Approval of reserved matters following outline consent WA/26/18/OUT for layout & scale for 6 No. dwellings & 6 No. detached garages.

Lanes End West Walberton Lane Walberton

Thank you for your internet representation made on 11th March 2019 which has been recorded as '**an objection**' with the comments as follows:

PJ DEVELOPMENTS LTD 2 Square Chambers 23 High Street Emsworth PO10 7AQ Tel: 0843 289 3430 Email: enquiries@pjdevelopmentsltd.com	
PROJECT: FORMER LANES END	
SITE PLAN OUTLINE PLANNING APPLICATION	
DATE: JANUARY 2019	DWG. NO 19-001 PL02
SCALE @ A1: 1:200	
REV: C

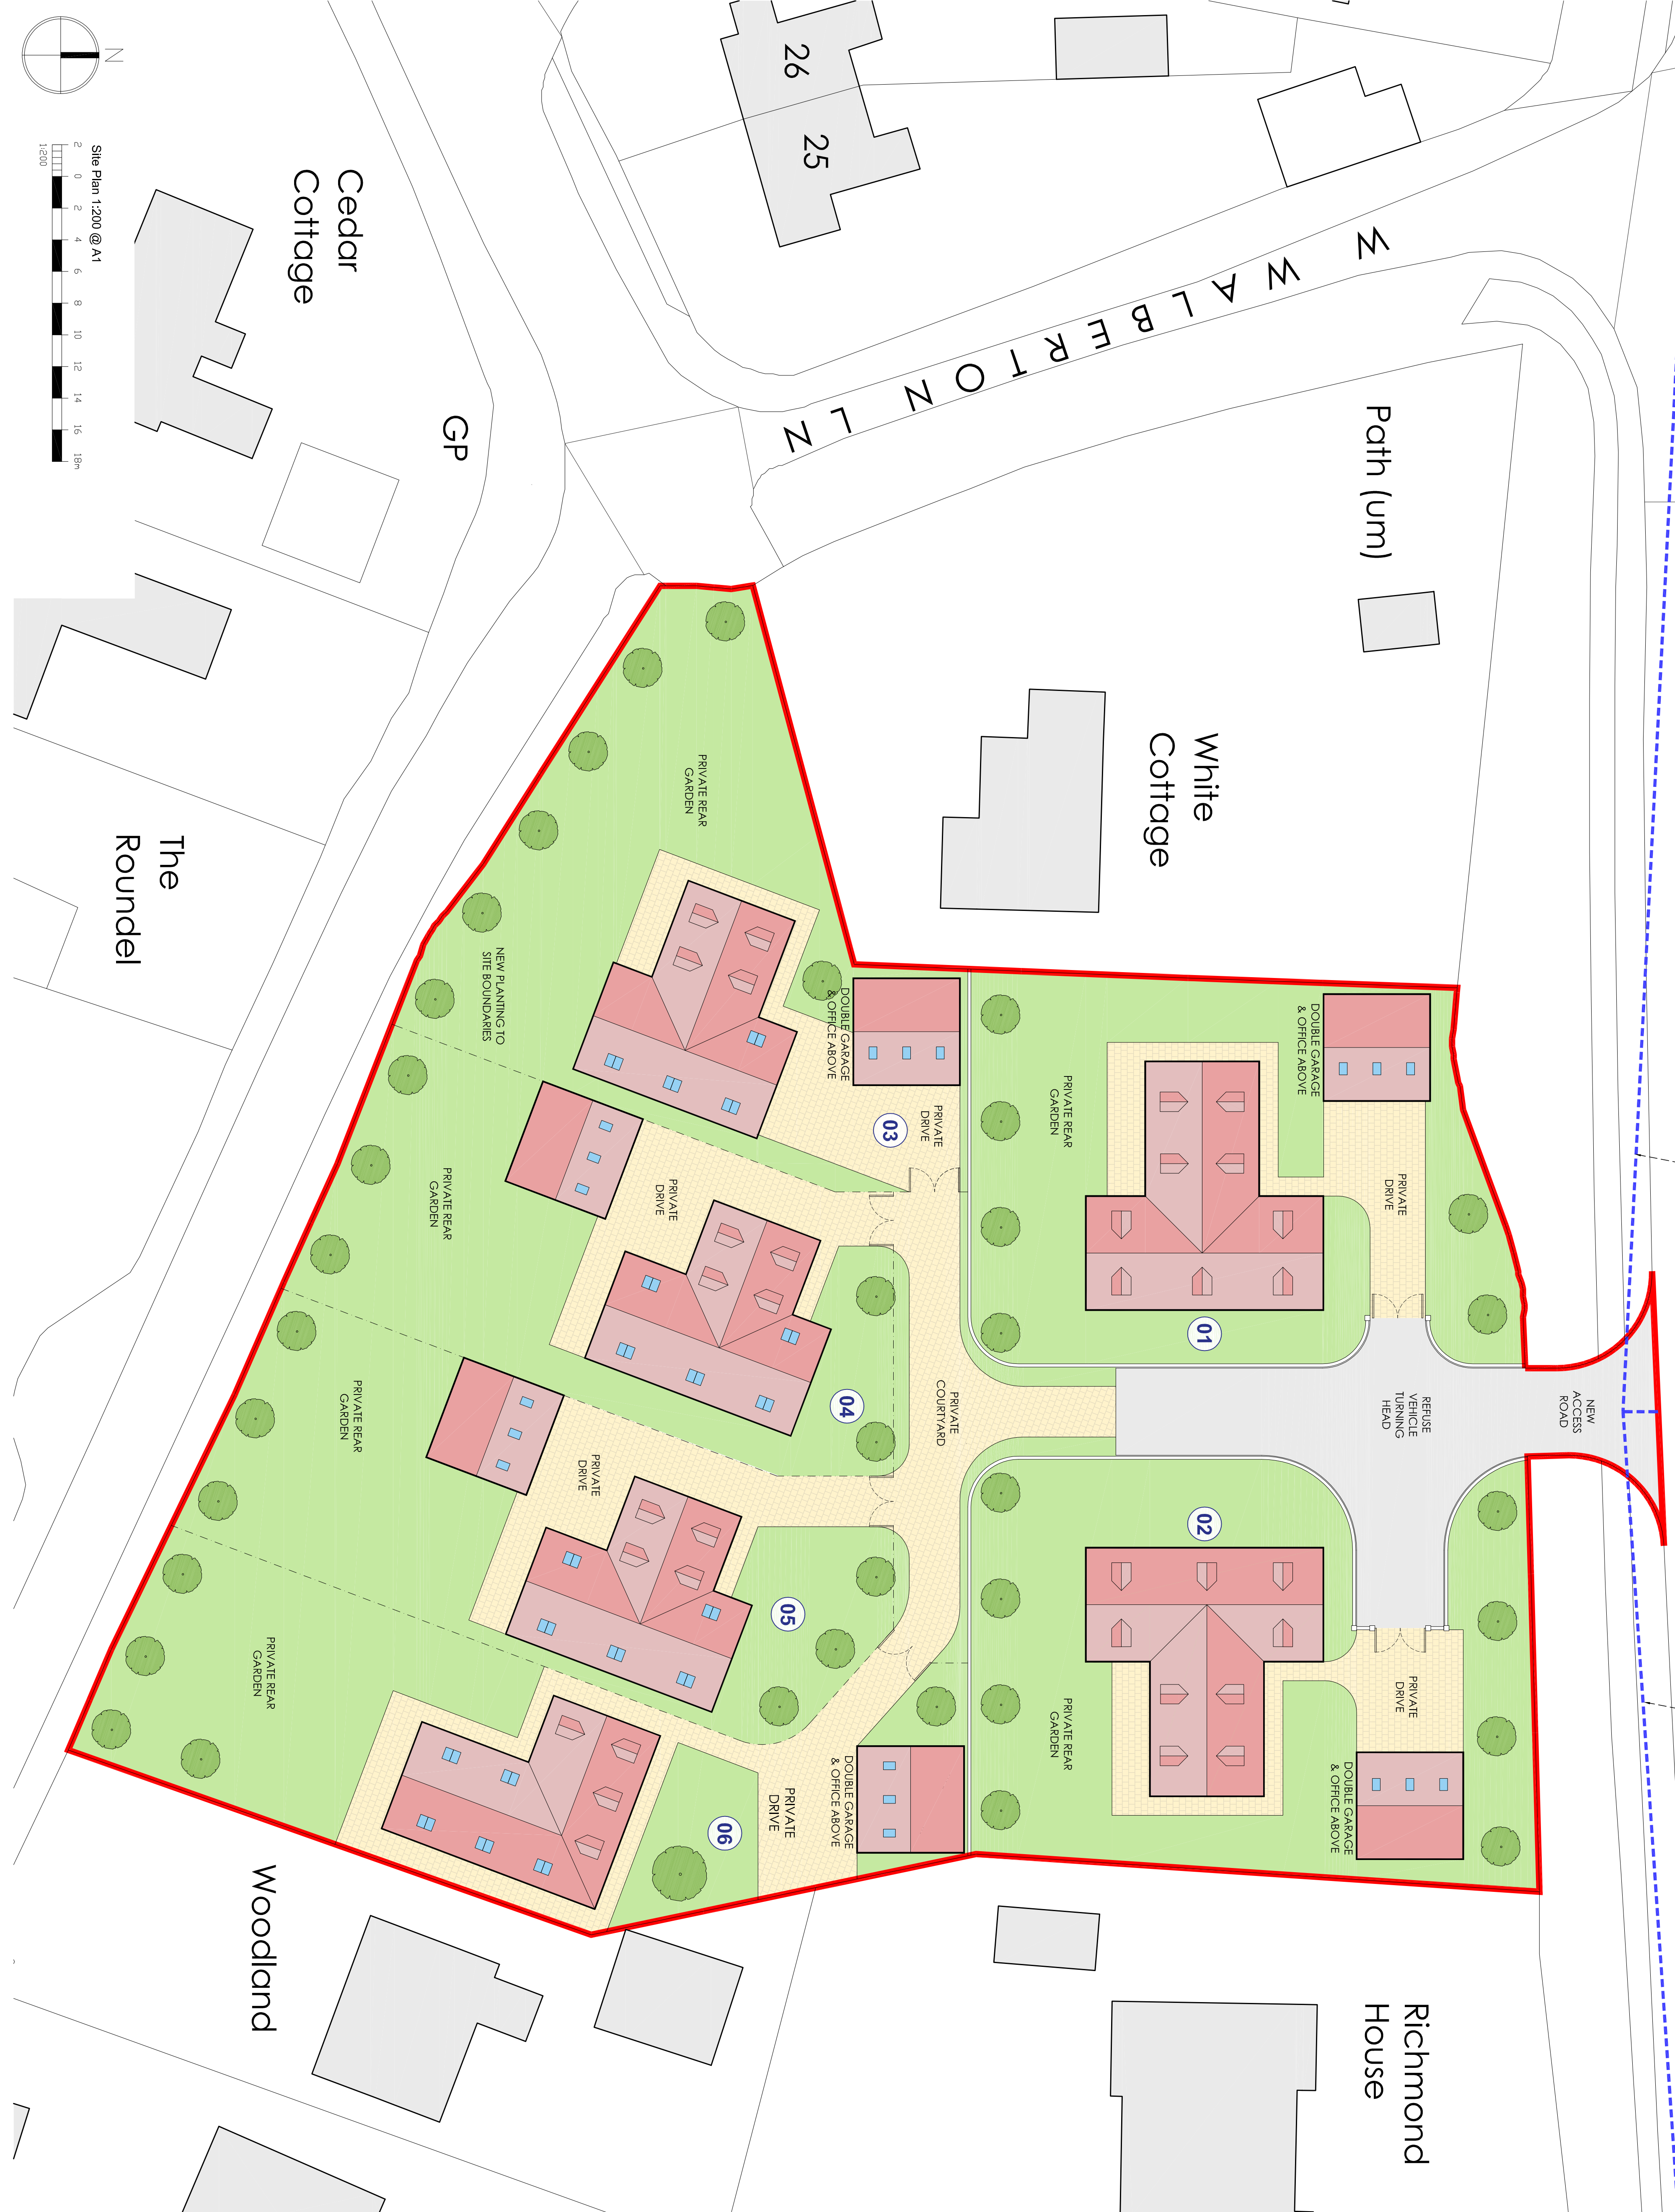
The layout of the development particularly the four houses in the southern half of the plot is alien to the properties fronting the top end of West Walberton Lane.

The removal of trees on the common boundary is contrary to that expressed by Mr Terry in his communication of 27 June 2018 to the Planning Officer in which he said inter alia "It is our intention that all mature trees on the boundary of the property remain. We of course would be more than happy with the condition that the mature trees must be protected." We await the Local Planning Authority's response.

Our outlook will change from a rural scene with a two floor level family residence some 30 metres or more away to an estate of three floor level houses with the nearest property less than 2 metres from the boundary at ground level and less than that at the overhanging eaves level. Overbearing to the point of threatening.

The windows shown in the roof of the nearest property will overlook our conservatory and bedrooms on the north west corner of our house. No doubt windows at second floor will do like wise and all windows on the east face will overlook our gardens.
